Our Reference: **PT23061**

**28 to 32 Bourke Road, Alexandria Health Centre Stage 2 SSDA
Response Report to Request for Information**

As requested we have reviewed the items pertaining to traffic, parking and access detailed in the Request for Information (RFI) from City of Sydney and Transport for NSW. This response report has been prepared based on the revised design plans provided in **Appendix A**.

LONGITUDINAL SECTION ALONG MC01
HORIZONTAL SCALE 1:200@A1
VERTICAL SCALE 1:500@A1

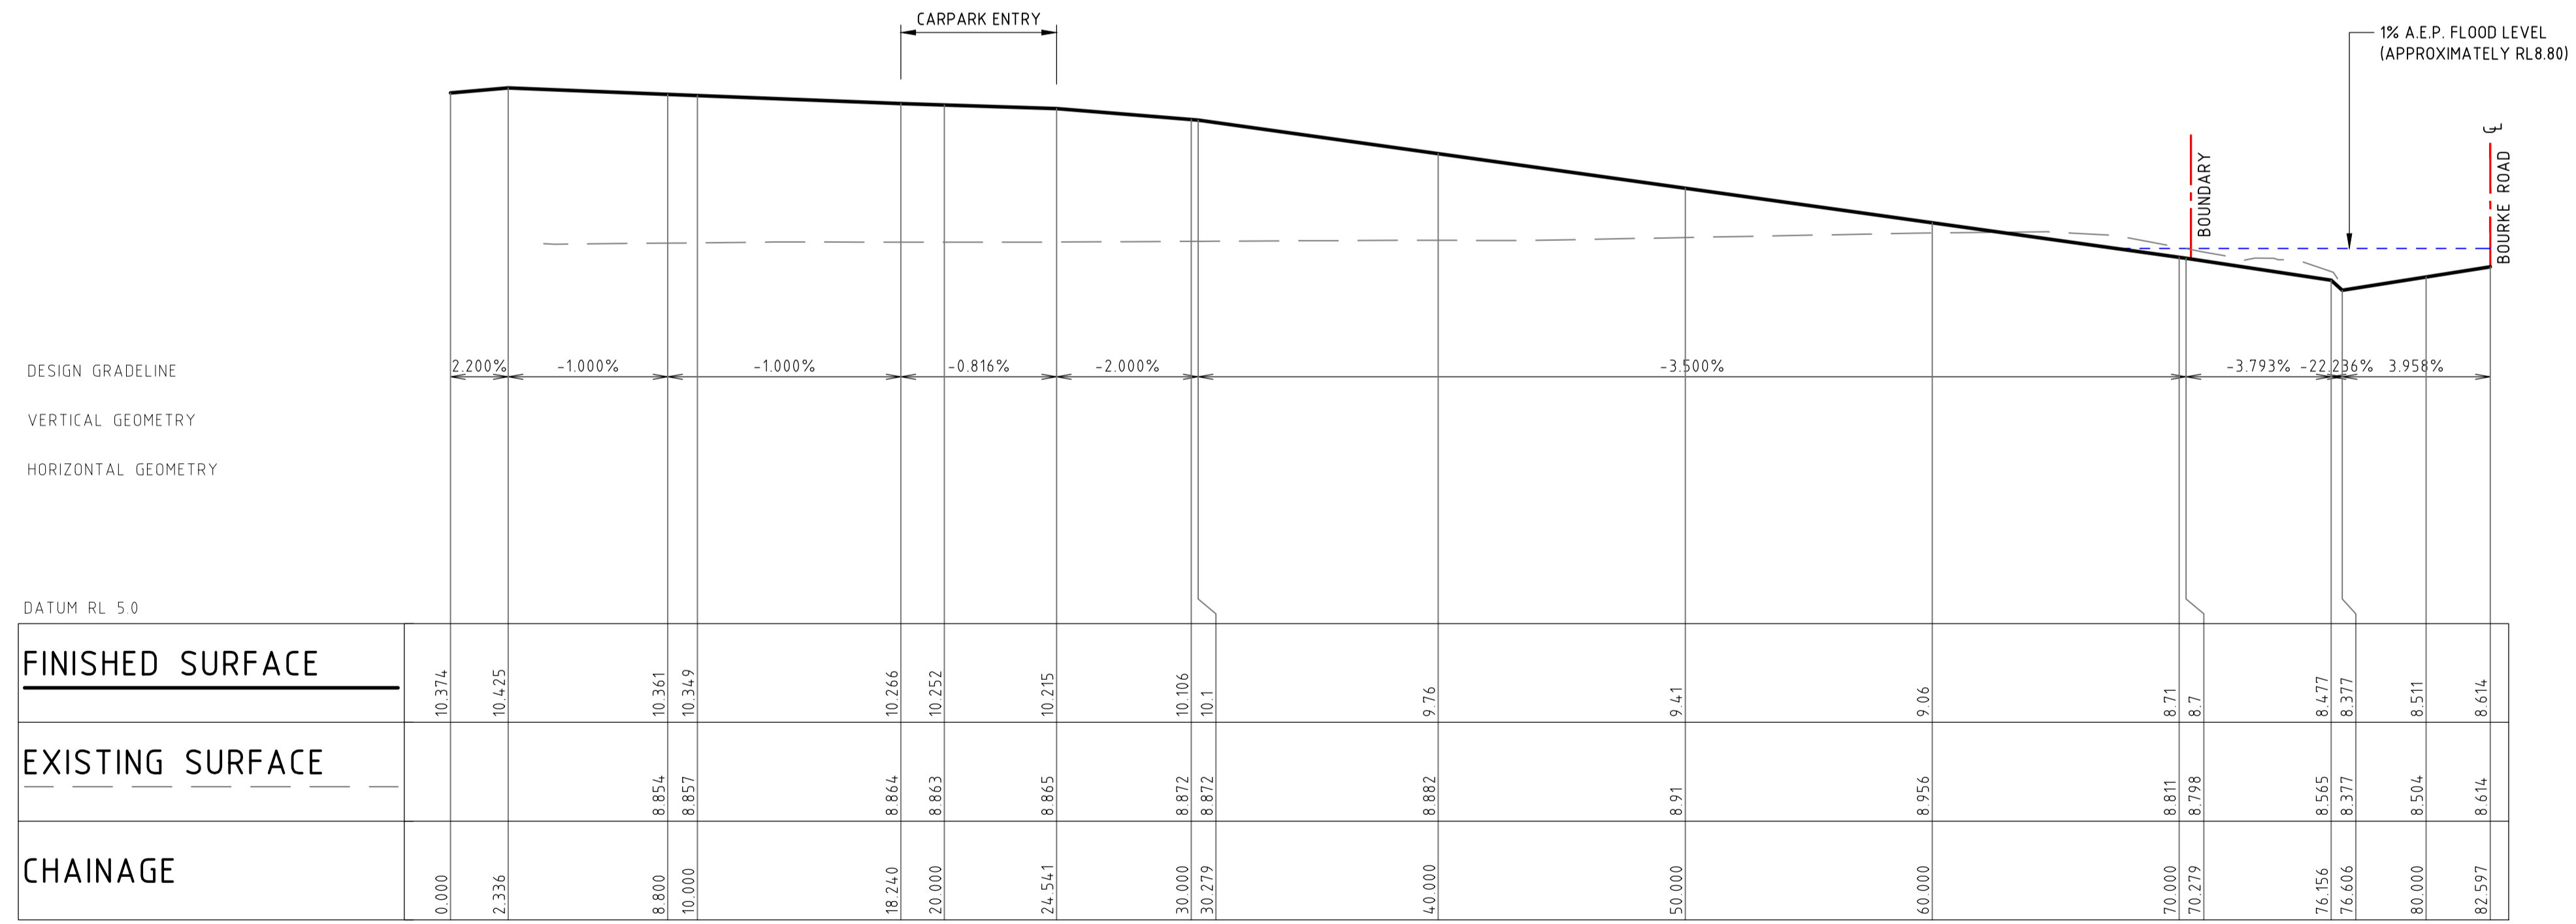
5c	The driveway will require the long section to be edited to show a swept path diagram of the design vehicle used in this application.
----	--

It appears and error in terminology in the above comment with swept paths shown on a long section which would not normally occur.

However, the revised design plans include grades of the new laneway access to the car parking areas of the site which confirm no part of the laneway would be greater in grade than 5.0% ensuring that vehicle scragging in any location of the laneway or vehicle accesses would not occur.

All grades of ramps proposed comply with the minimum requirements of AS2890.1 and do not include changes in grade beyond the recommended maximums of the standard.

**Drawing Title**  
**GROUND FLOOR GENERAL ARRANGEMENT PLAN**  
**Drawing Status**  
STAGE 2 SSDA

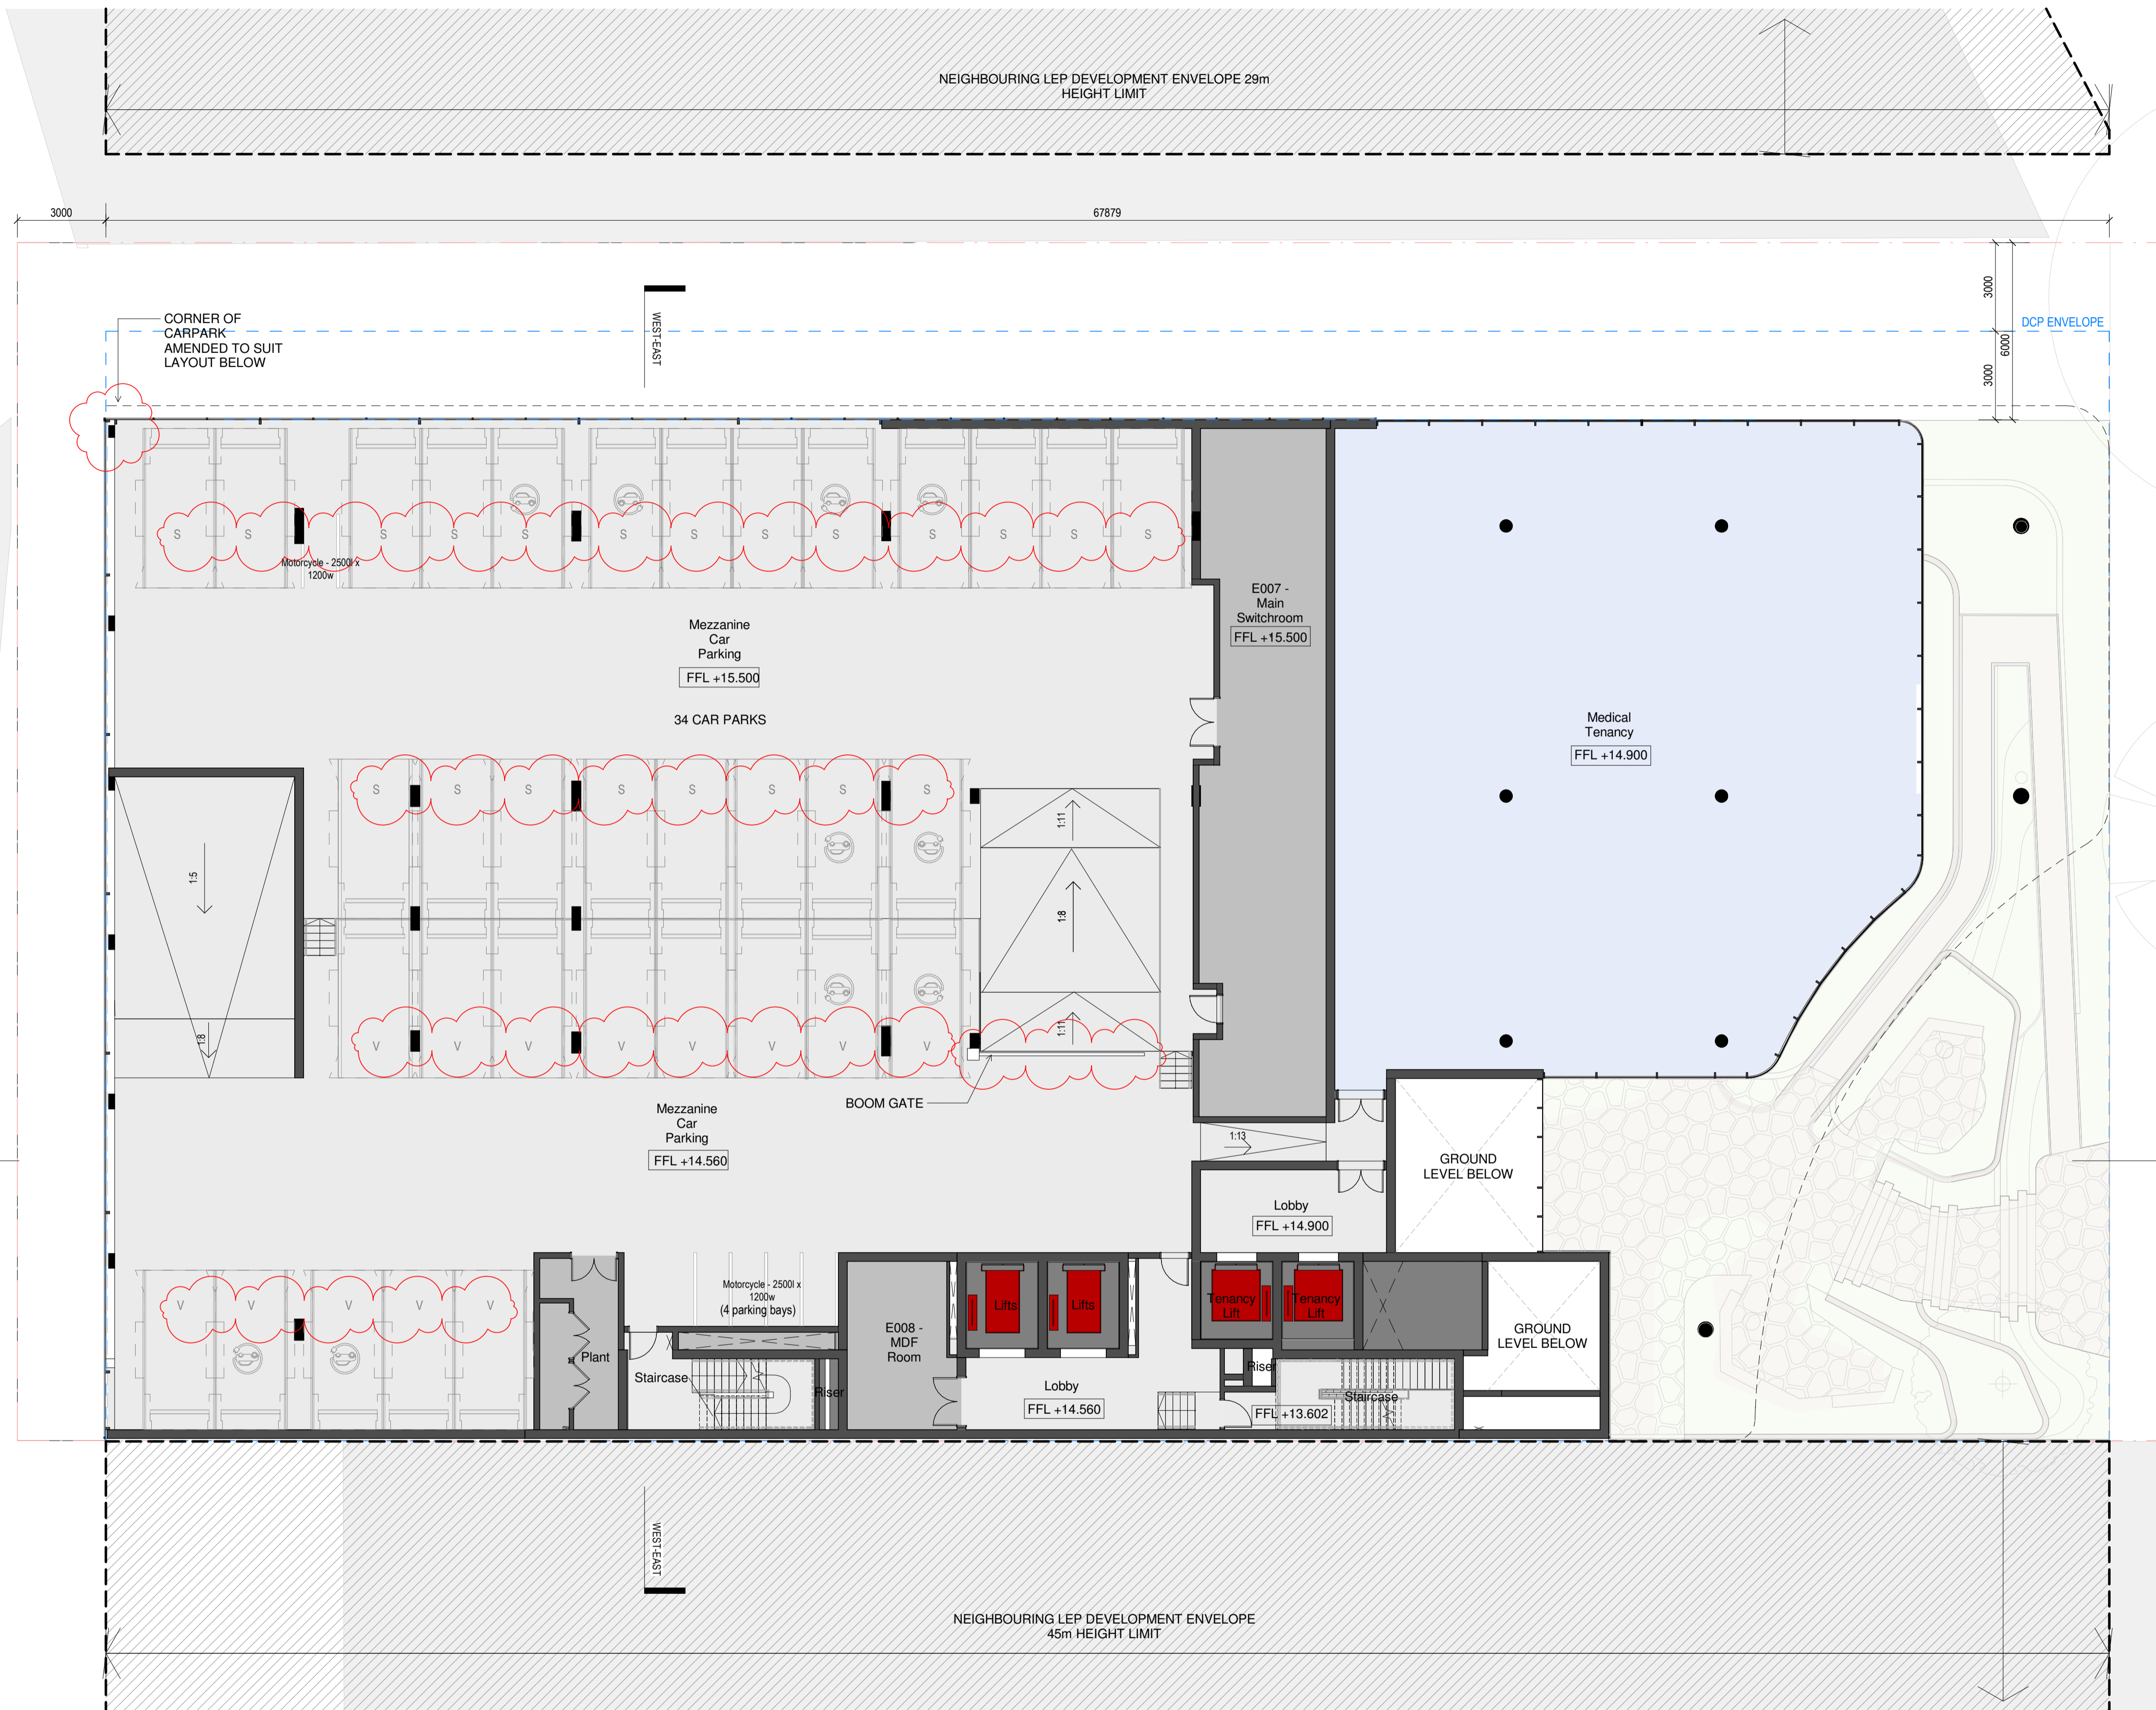
5d	It is recommended that clarification be provided if the 4 x accessible car parking spaces will be allocated to staff.
----	---

5f	It is recommended that the door opening zone for accessible car spaces be located away from vehicle traffic.
----	--

The four accessible spaces, which equates to approximately 5% of the total parking provision, which is generous, would be publicly available at all times and also used by those staff who require access to an accessible parking space.

The boom gate control has been relocated further into the ground floor to ensure access to accessible spaces at all times.

All door opening zones of accessible parking spaces on the ground floor open inward to the central area of each pair of parking spaces. Further, only informed drivers (staff) would travel past these accessible spaces.

**Drawing Title**  
**GROUND FLOOR MEZZANINE GENERAL ARRANGEMENT PLAN**  
**Drawing Status**  
STAGE 2 SSDA

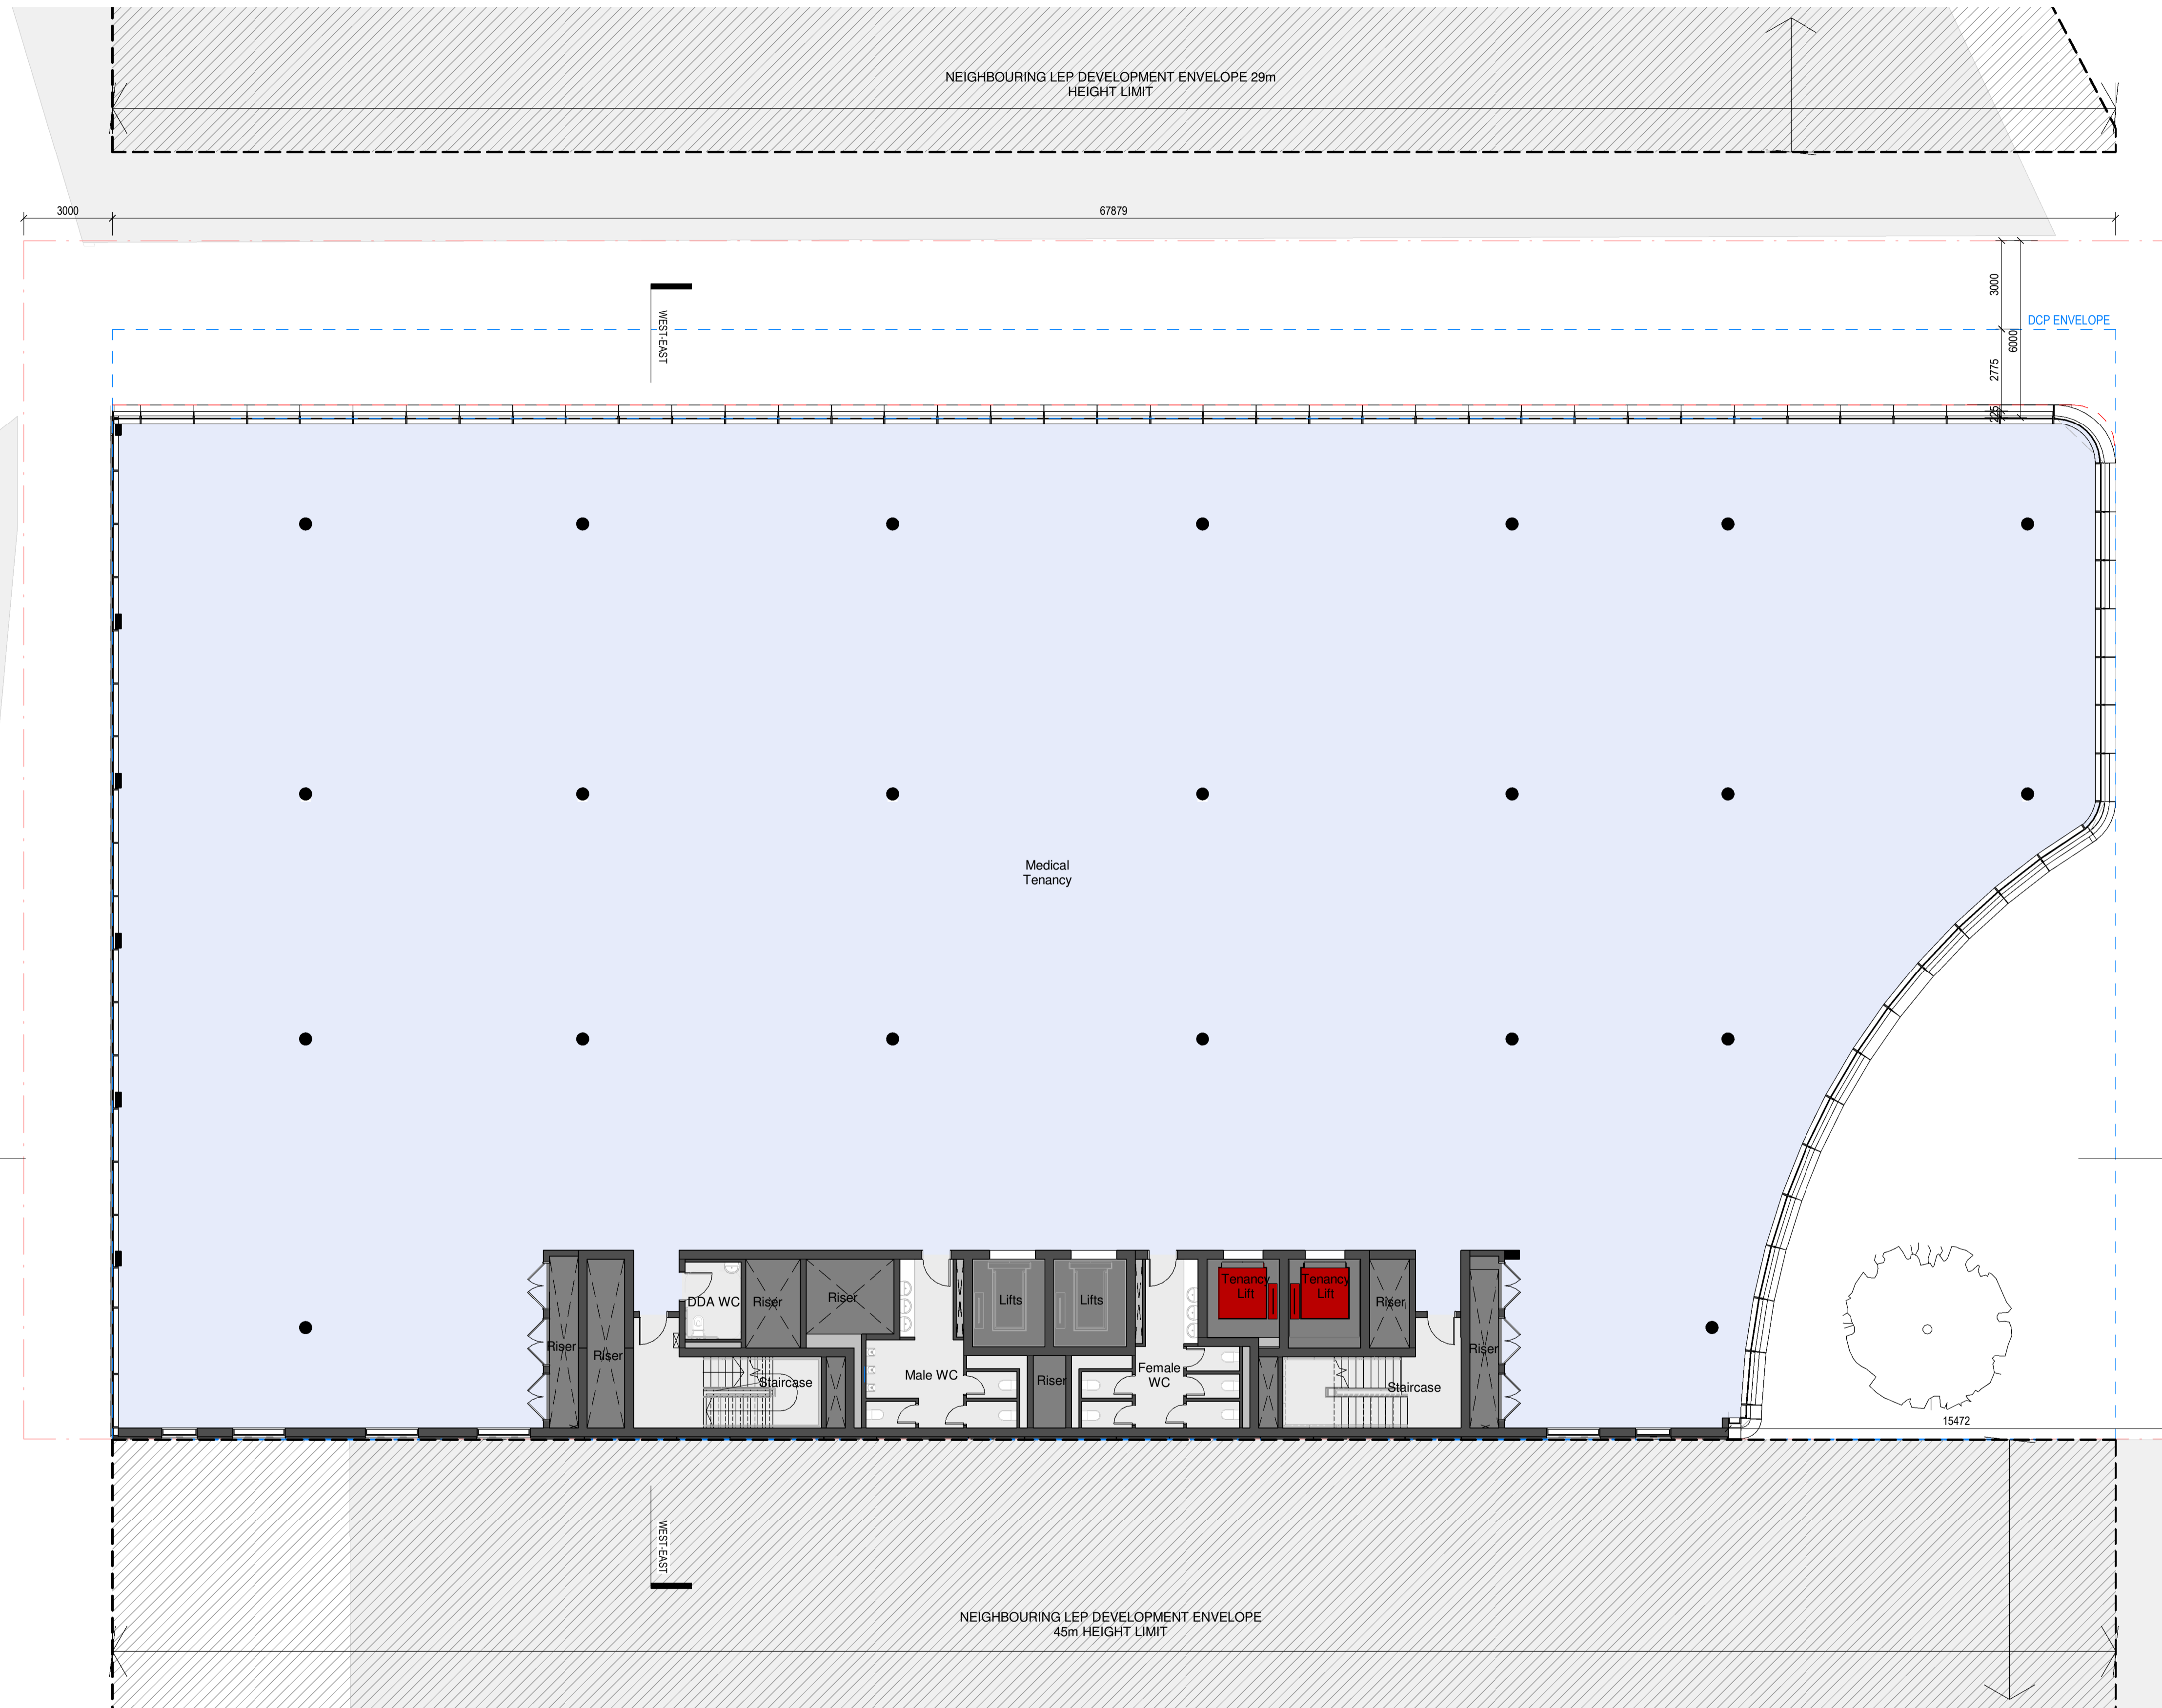
5i	The driveway access should be designed to accommodate simultaneous operation by two vehicles - one entering and one exiting side by side. A vehicle swept path analysis must be prepared to demonstrate the feasibility of two-way movements within the driveway access and ramp.
----	---

As stated above, the ramp access to the mezzanine level has been widened at the boundary to allow two (2) light vehicles to pass concurrently as per the requirements of AS2890.1. These turning paths are provided in [Appendix B](#) of this response report.
